CITY OF ALBUQUERQUE

RE: 1719 5th St. NW
Grading and Drainage Plan
Engineer's Stamp Date: 11/04/21
Hydrology File: H14D100

Based upon the information provided in your submittal received 11/23/2021, the Grading & Drainage Plan and Drainage Report **is not** approved for Building Permit. The following comments need to be addressed for approval of the above referenced project:

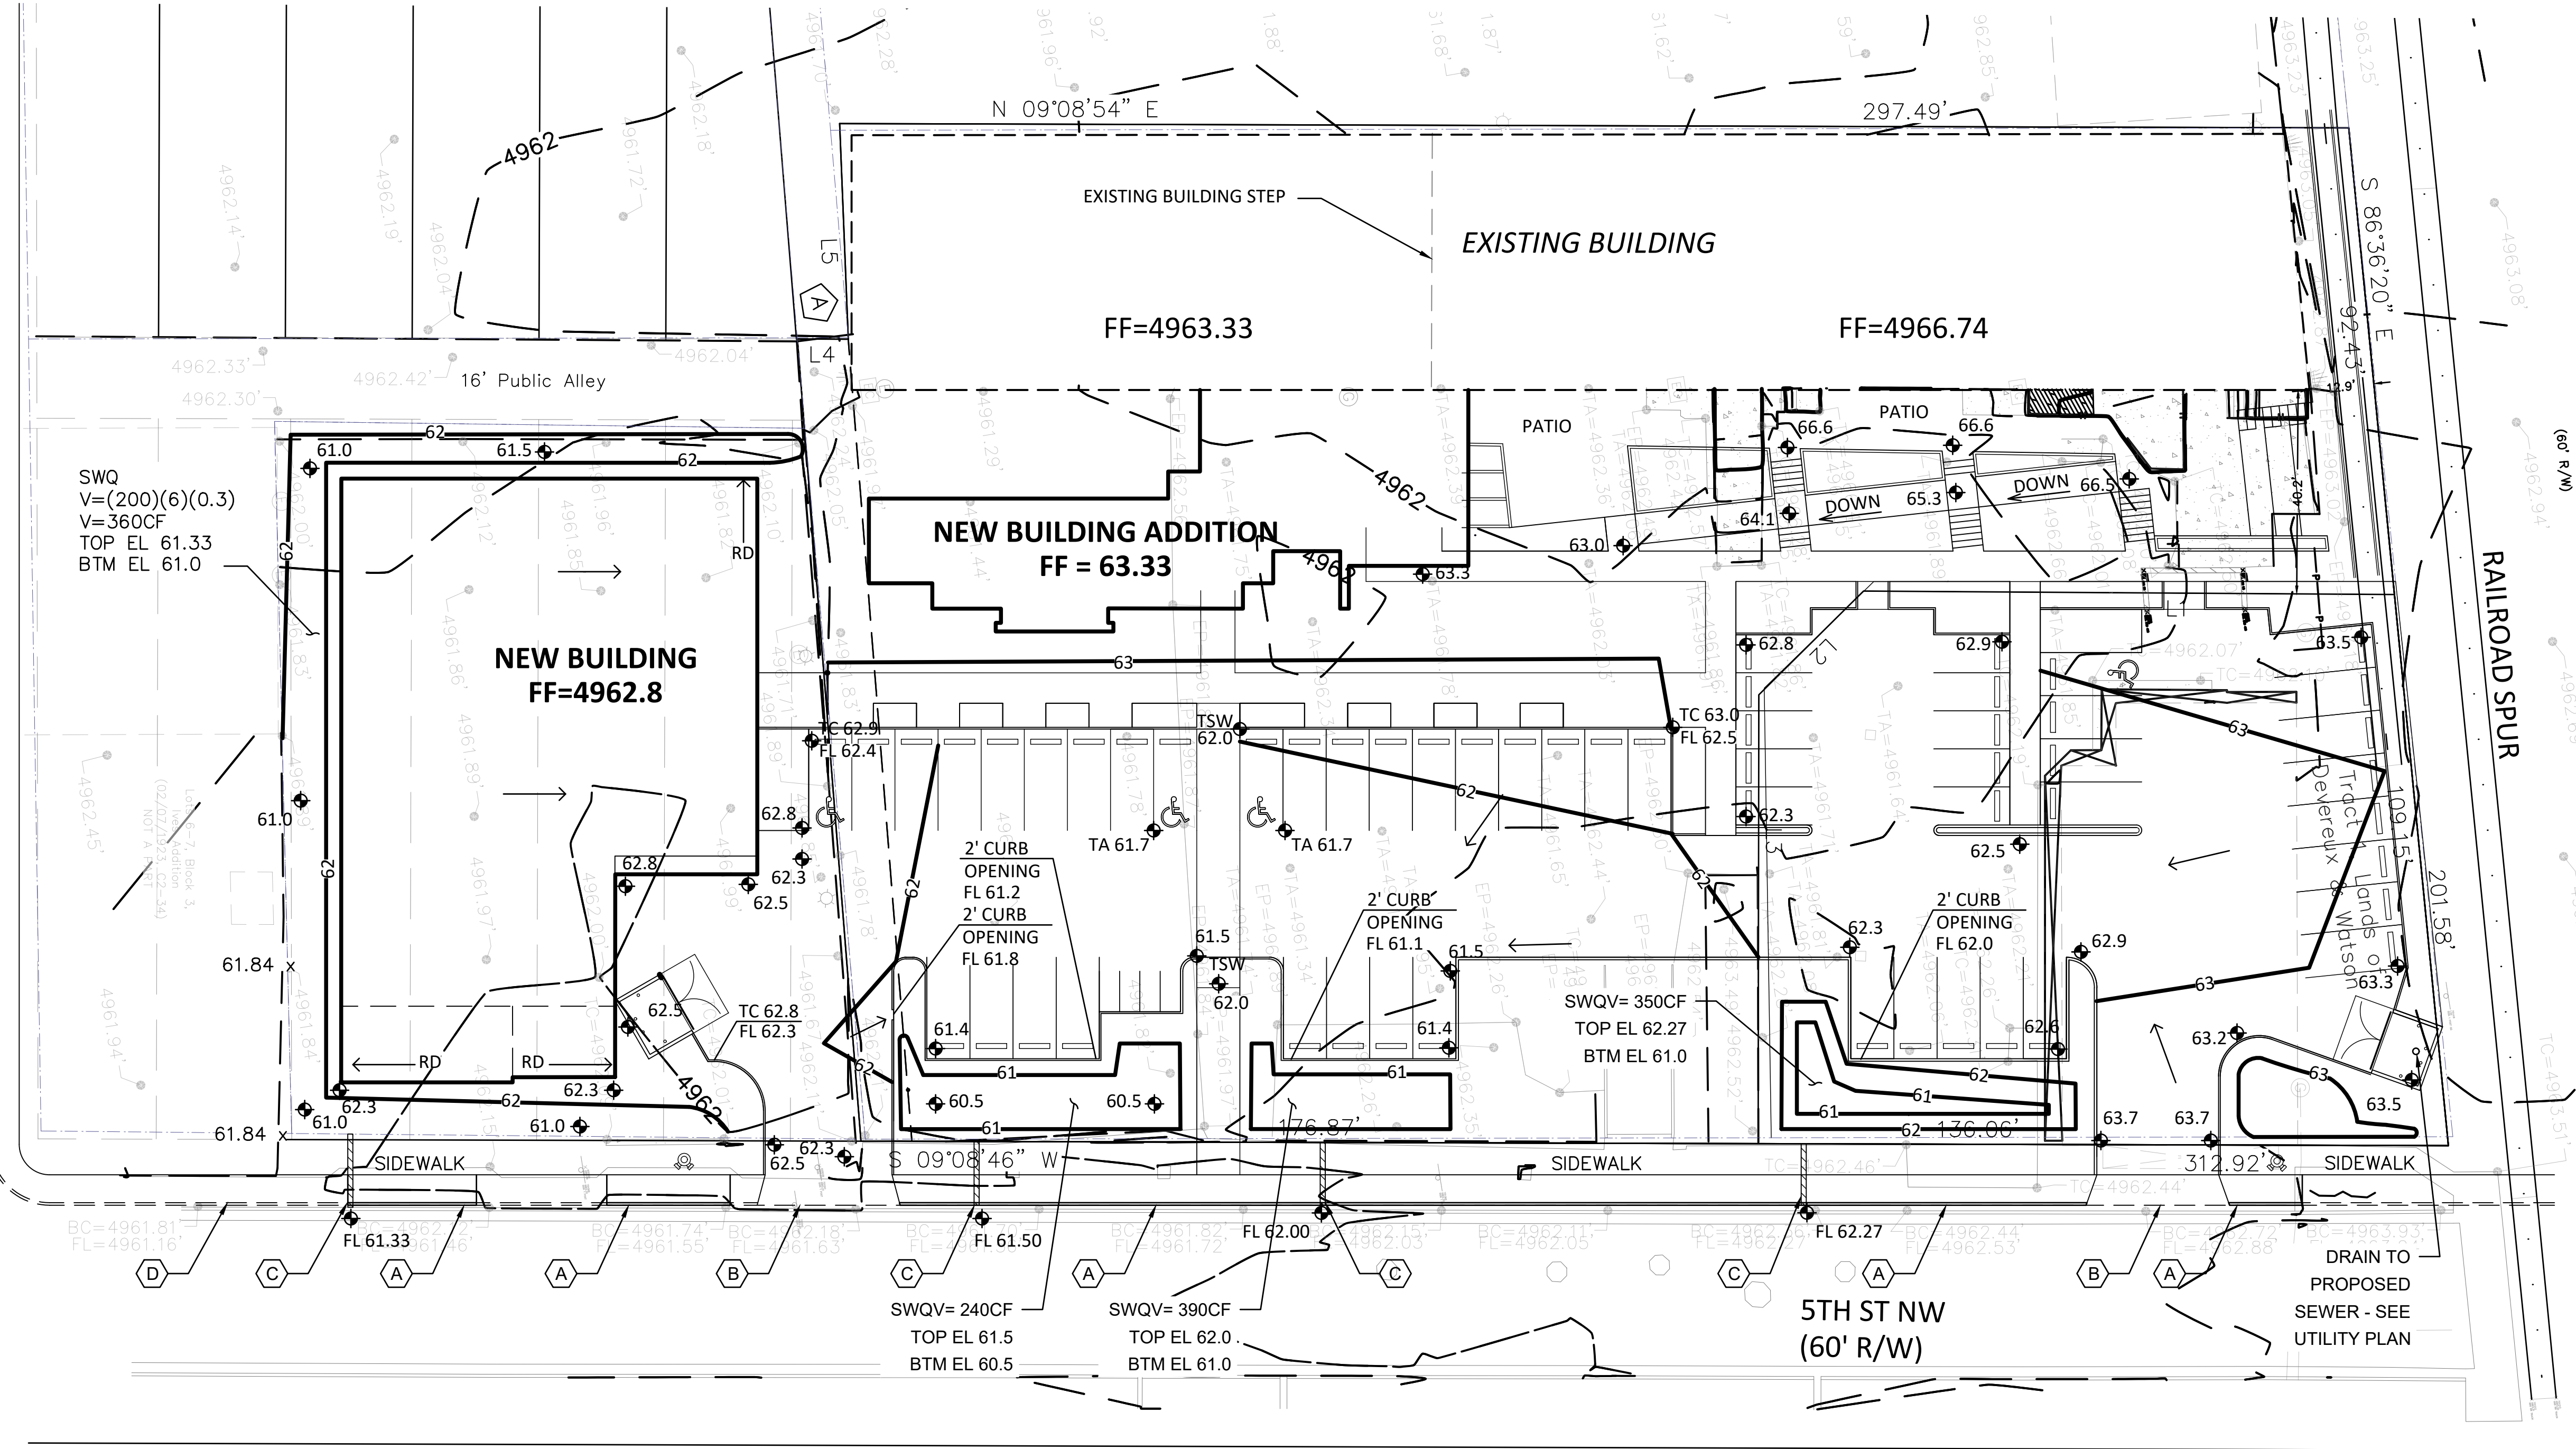
1. It is unclear what is being constructed and what is existing. It is not Hydrology's job to guess and if I can't tell, I know the contractor will not be able to tell as well. In places the line work for the existing is the same line weight as proposed. The only items that stands out are the proposed contour lines. Is the proposed pavement asphalt? At the edge of pavement at places there is a call out of top of curb and at others there is just a spot elevation but the line work is the same at both spots a single line it is not clear where the proposed curbing onsite starts and where it stops. The standard for a curb is a double line. Please clean this up.

2. It appears that there is proposed grading and construction work being done on a tract of land that is not owned by the project Owner. Provide written and signed permission from the adjoining property owner for work on their property. This should be notarized.

3. Again, it is unclear at what is being constructed within 5th Street R.O.W.

At this property's southeast corner of the property line, there is a massive drive for trucks when this existing building was a warehouse. This massive drive extends all the way till right before the railroad spur where there is a curb & gutter. So please indicate on the drawings where the proposed curb & gutter starts and where it ends with existing grades at the existing curb & gutter locations. Also, please replace any traffic signs that are present.

- The entrances proposed on 5th St. do not adhere to the City's private entrance detail #2426. These entrances need to provide curb returns and ADA ramps as shown. This drive is also needed to ensure the water block requirement as shown in the detail.

- Please call out the stormwater quality ponds and include the provided SWQV and elevation of the SWQV and the bottom of the pond elevation. Also, please connect the ponds with a pipe so that the spillway required is just one sidewalk culvert.

6. Please reference City of Albuquerque standard detail No. 2236 – Sidewalk Culvert with Steel Plate Top at the sidewalk culvert. Also, please provide the invert elevation inside the SWQ pond (this should be equal to the SWQV elevation) and the invert at the gutter.
7. Please provide the weir calculations, per DPM Article 6-16(A), for the sidewalk culverts. A coefficient of 2.7 is typically used for the weir equation $Q = CLH^{2/3}$.
8. For trash enclosures serving food service developments, demonstrate control of liquids from dumpster areas per DPM by: containing runoff from the dumpster area, preventing outside drainage from entering the dumpster area, and discharging to the sanitary sewer. Please show the inlet and state, “Drain to proposed sanitary sewer. See Utility Plans”.
